Our ref: WA/2016/121827/01-L01
Your ref: 15/02103/REM
Date: 26 February 2016

Reserved matters to application 06/00967/OUT - provision of local centre to include community centre (CLASS D1), youth centre (class D1), nursery (class D1), convenience store (class A1), 4 x retail units (class A1/A2/A3/A4 and/or A5) and associated development including public square, landscaping, car parking, recycling point and ancillary servicing yard off Whitelands way, at the Kingsmere development, south west Bicester.

Formerly 2 Whitelands Farm, Cottages Street From Middleton Stoney Road To Whitelands Farm, Chesterton, Bicester, OX26 1RS

TITLE: INDICATIVE SURFACE WATER DRAINAGE STRATEGY

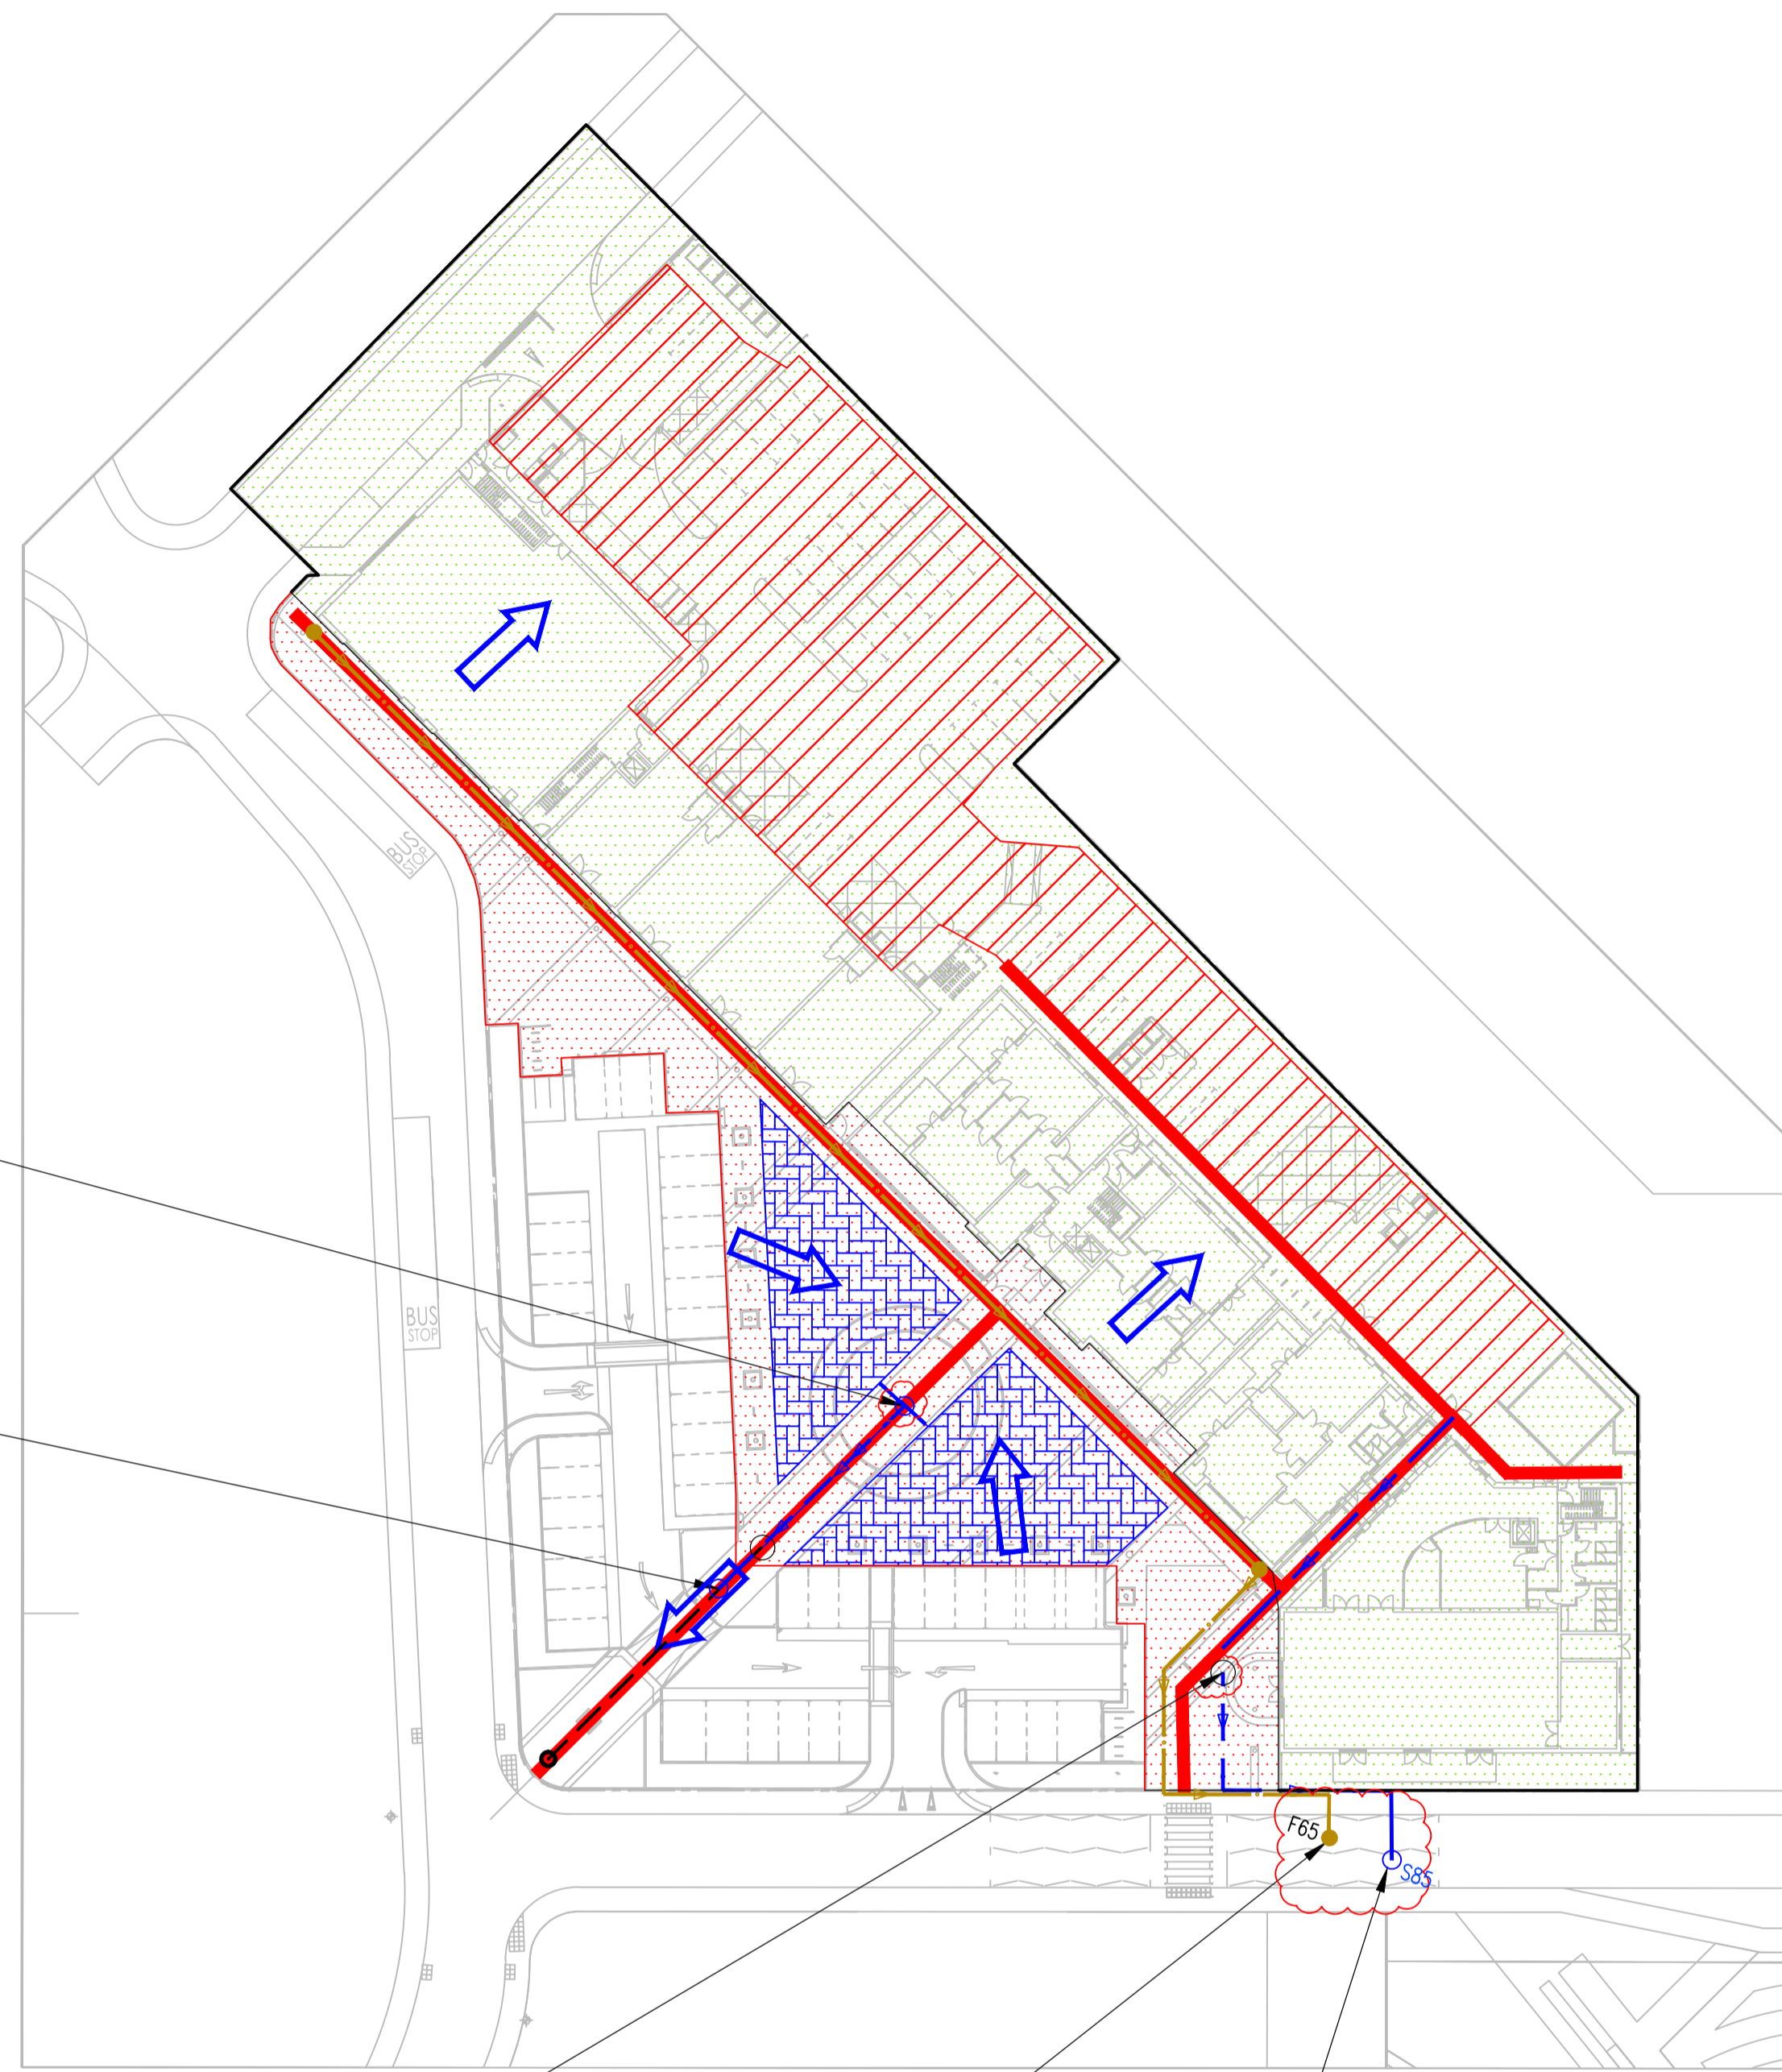
site wide drainage strategy that this reserved matters application complies with. It mentions that the piped network will drain the car park to the agreed rate of 8/l/s for the 1 in 10 flood event.

No information has been submitted which explains in detail how this application site will drain in a flood in excess of a 1 in 10 year flood event up to the 1 in 100 year plus a suitable allowance for climate change. This information is required to understand if this application site floods for any event up to the 1 in 100 year flood event and if so where.

We are currently in the transitional period of handing over consultation for surface water flooding to the Lead Local Flood Authority (LLFA). We advise that the information above is requested from the applicant and the LLFA is consulted when it comes in.
